Our Ref: 24/00871/HFUL
Your Ref: 43 High street Over

South Cambridgeshire District Council Application for Planning Permission

Proposal: First floor rear extension over existing house and single storey extension to outbuilding, following demolition of existing sheds and conservatory.

Site address: 43 High Street Over Cambridgeshire CB24 5NB

CLIENT:	Justin & Anita Piani
PROJECT:	43 HIGH STREET OVER CAMBS CB24 5NB
TITLE:	EXISTING LAYOUTS & LOCATION PLAN
SCALE:	1:50@A1
DATE:	26.11.2024
DRAWN BY:	P.W.
CAD REF:	43HIST-OV1-01c
DWG No.:	43HIST-OV1-01A

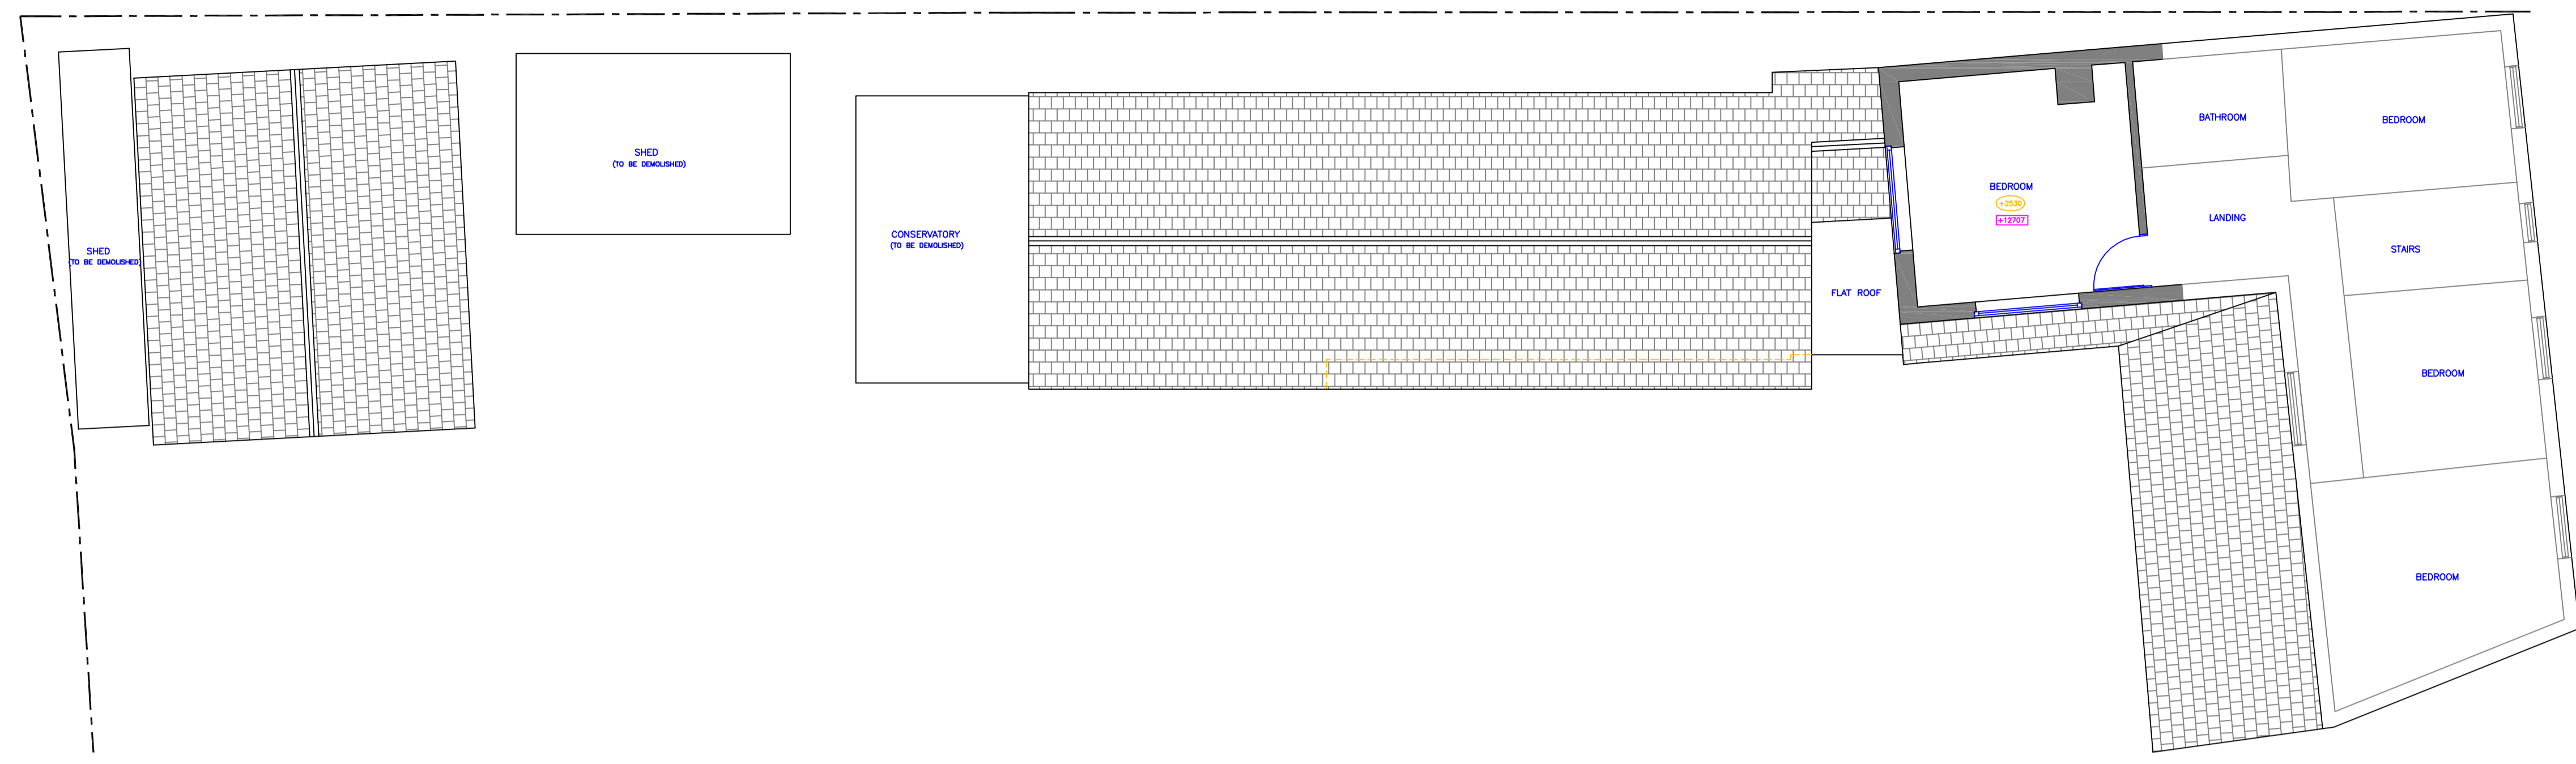
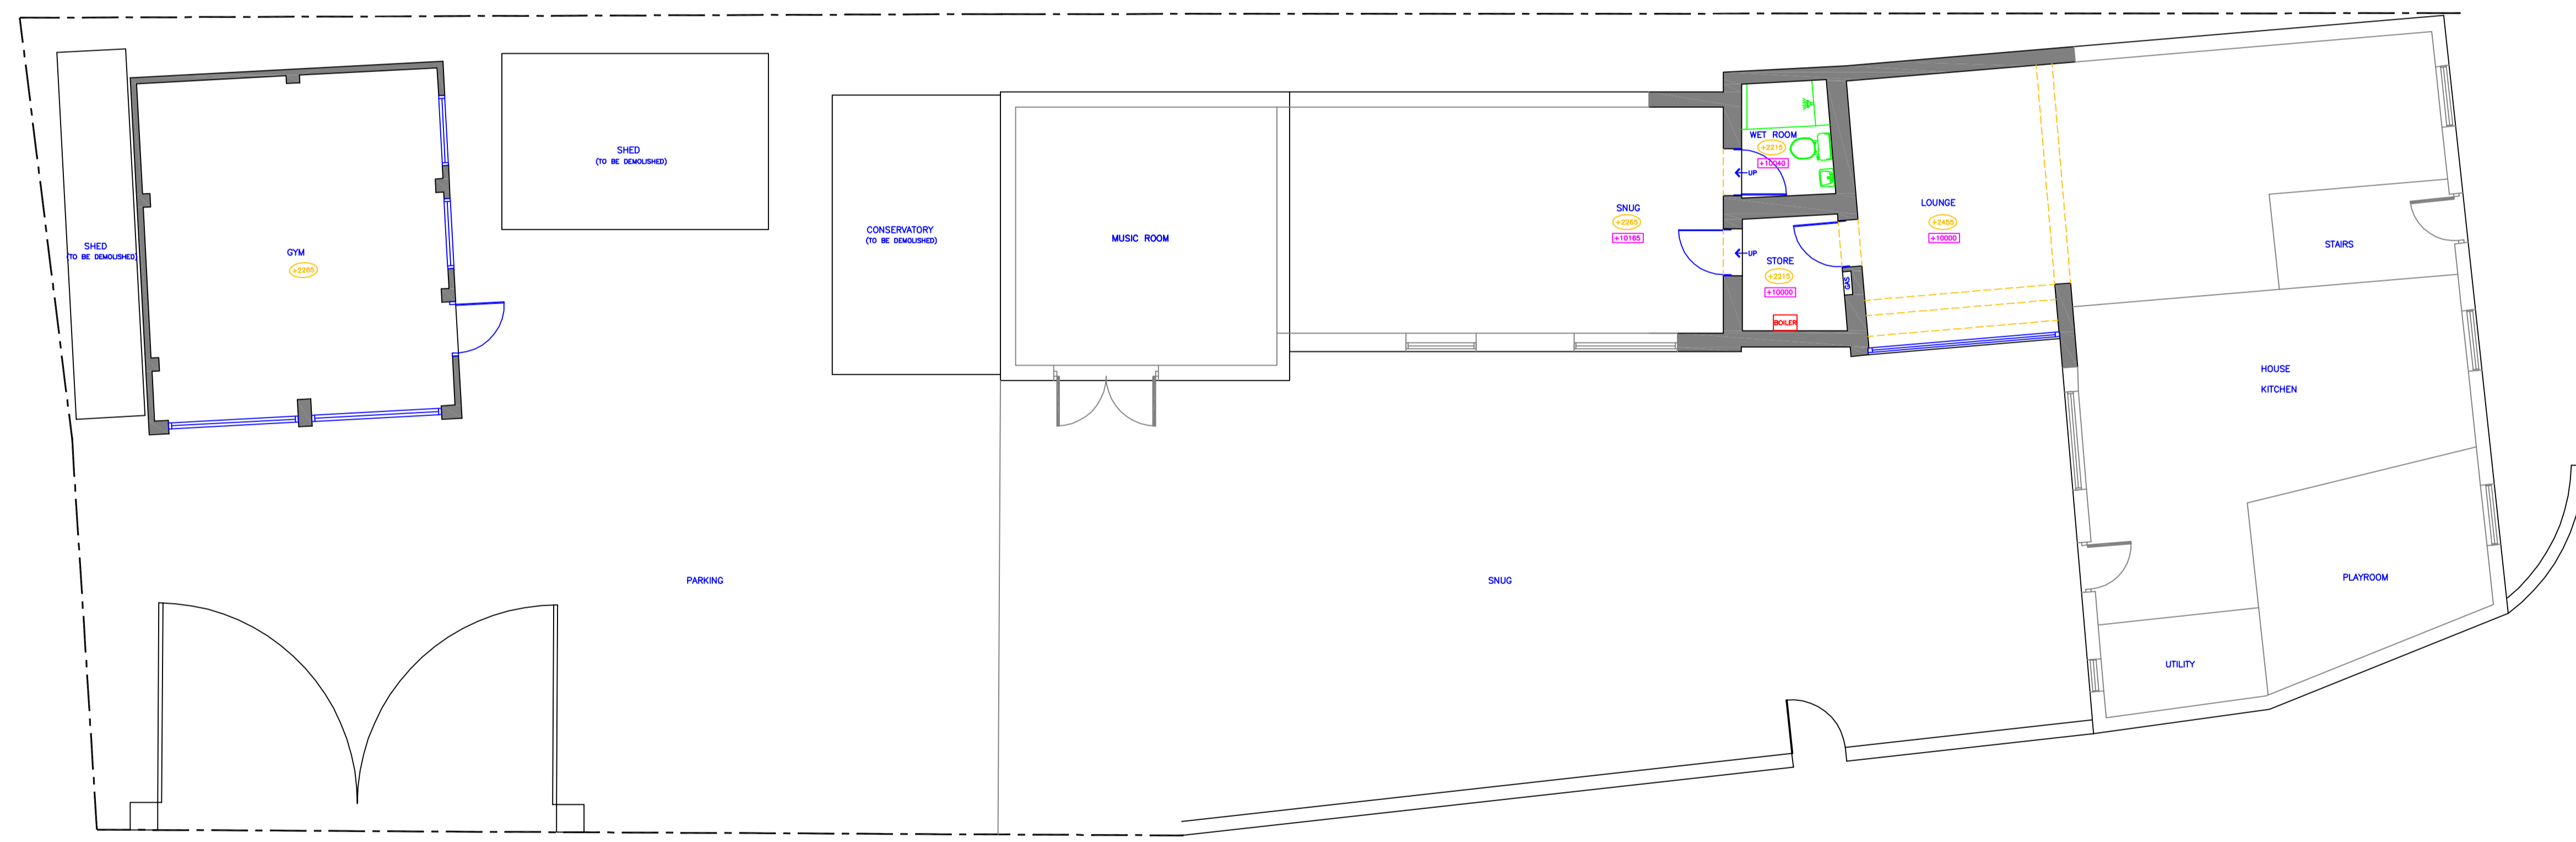
1. Please provide existing floorplans. Please ensure these are at a scale of 1:50/1:100 and show demolition of walls/buildings

As per planning officer advised please provide the existing floor plan for the entire house. The plan we have received only showing the partial existing floor plans.
